From: Carmichael Ian <Ian.Carmichael@thamesvalley.pnn.police.uk>
Sent: 22 April 2020 13:39
To: Samantha Taylor
Cc: Planning
Subject: Planning ref: 19/01047/OUT (AMENDMENTS). Land North East of Oxford Rd West of Oxford Canal and East of Bankside Banbury.

Planning ref: 19/01047/OUT (AMENDMENTS). Land North East of Oxford Rd West of Oxford Canal and East of Bankside Banbury.

Crime Prevention Design Advisor | Oxfordshire | Local Policing | Thames Valley Police

Figure 9:
Indicative Street Hierarchy

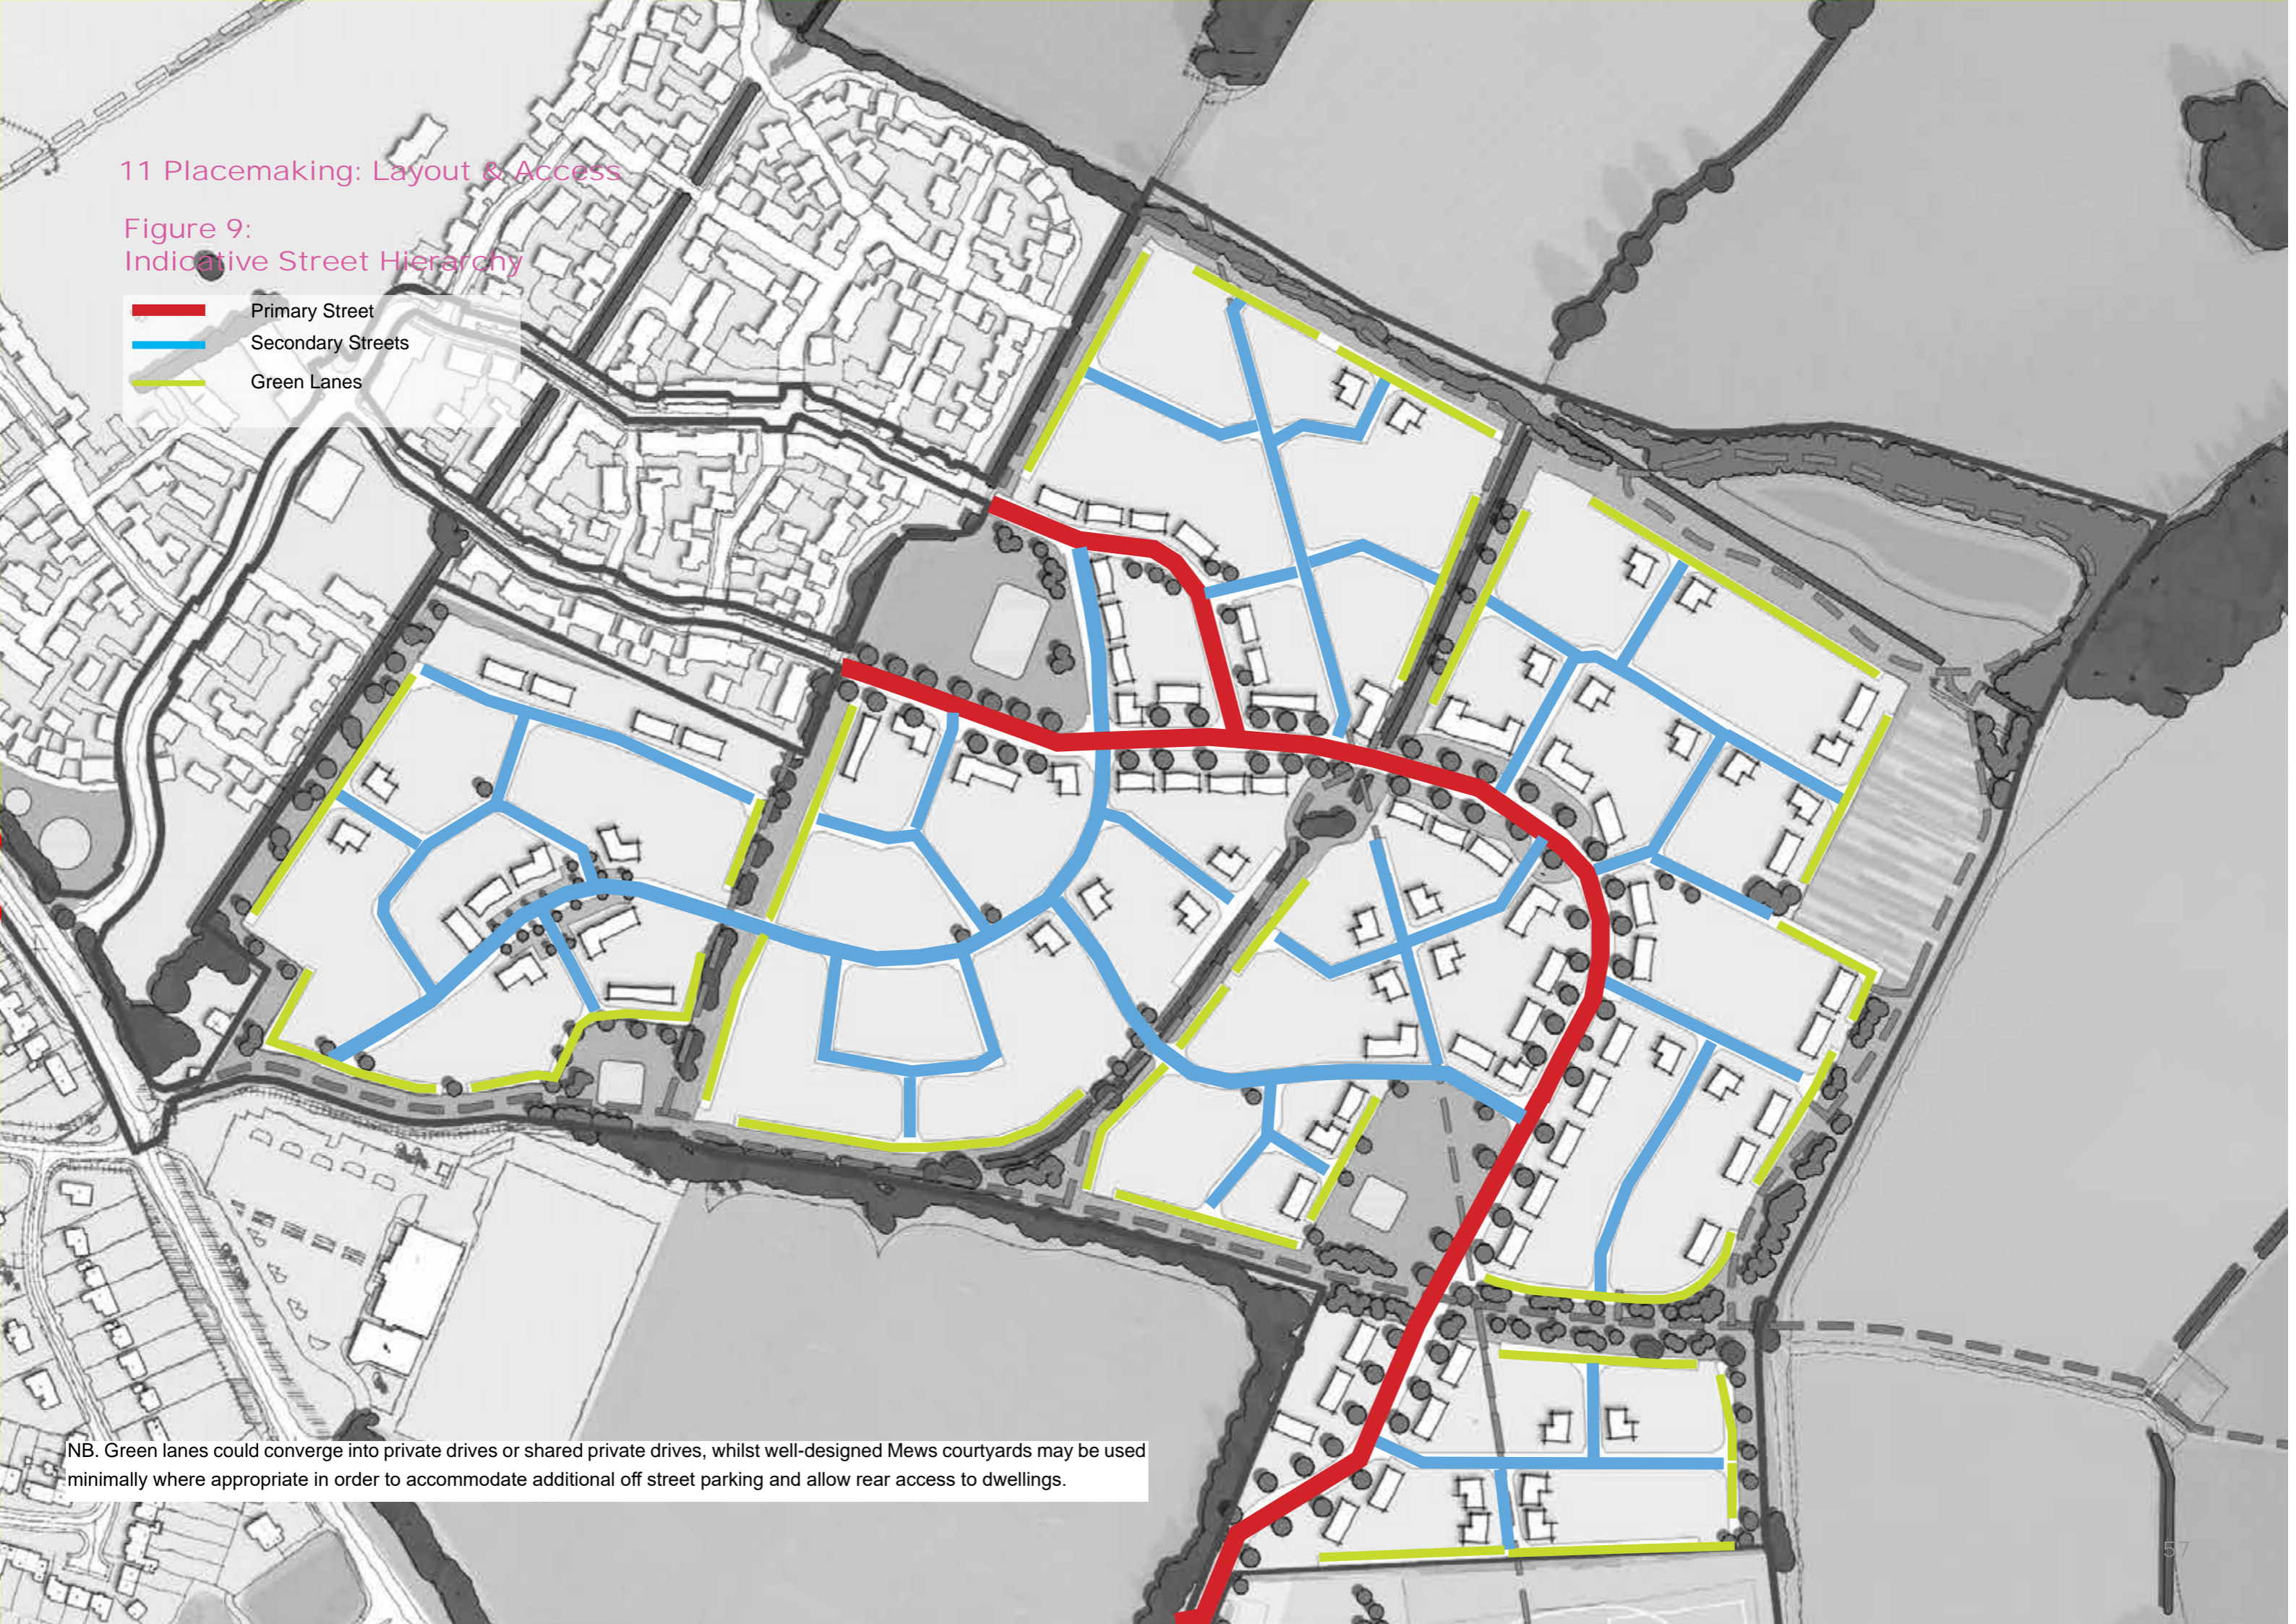
- Permeability is frequently mentioned throughout the DAS as a desirable quality within development. Although this is true, inappropriately high levels of permeability are likely to attract crime/anti-social behaviour (ASB), aid criminal search behaviour and provide escape routes for offenders. All routes should lead directly to where people want to go, serve a defined purpose and follow SBD guidance on their design. Permeability for permeability's sake should be avoided.

Parking

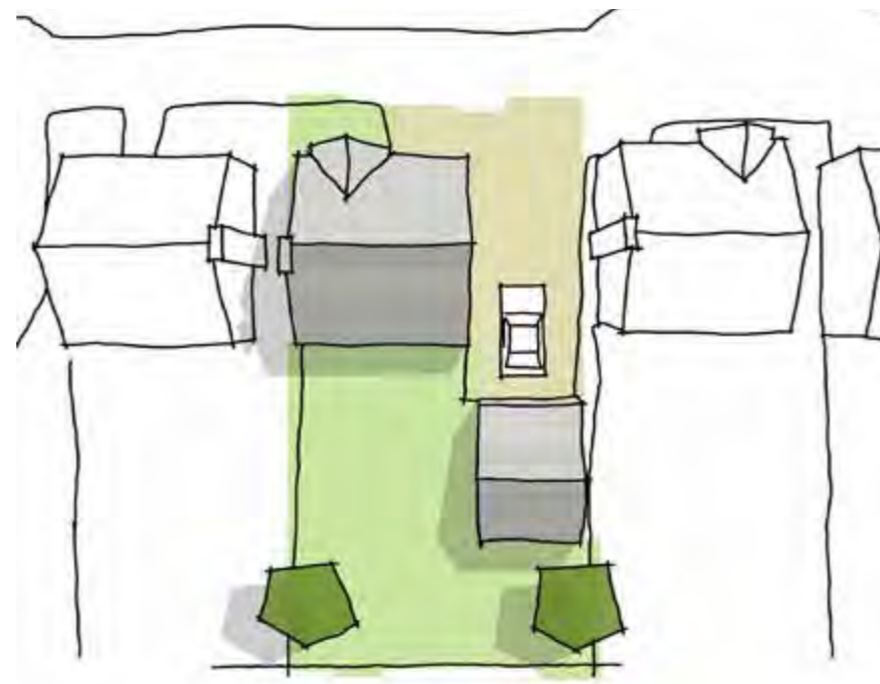
In relation to car ports and undercrofts, of course I recommend that they are not used. However, if some have to remain for some reason, they should be lit using a switched photoelectric cell unit, be overlooked from active rooms of adjacent properties and be gated. Ideally, I would prefer to see garages provided instead because car ports/undercrofts are unsecure, create hiding places and make vehicles, property and people vulnerable.

- In addition to the above, car ports and undercroft parking is proposed. Again, these features can be problematic as they are unsecured, create hiding places and make vehicles, property and people vulnerable. I would prefer to see secure garages provided.
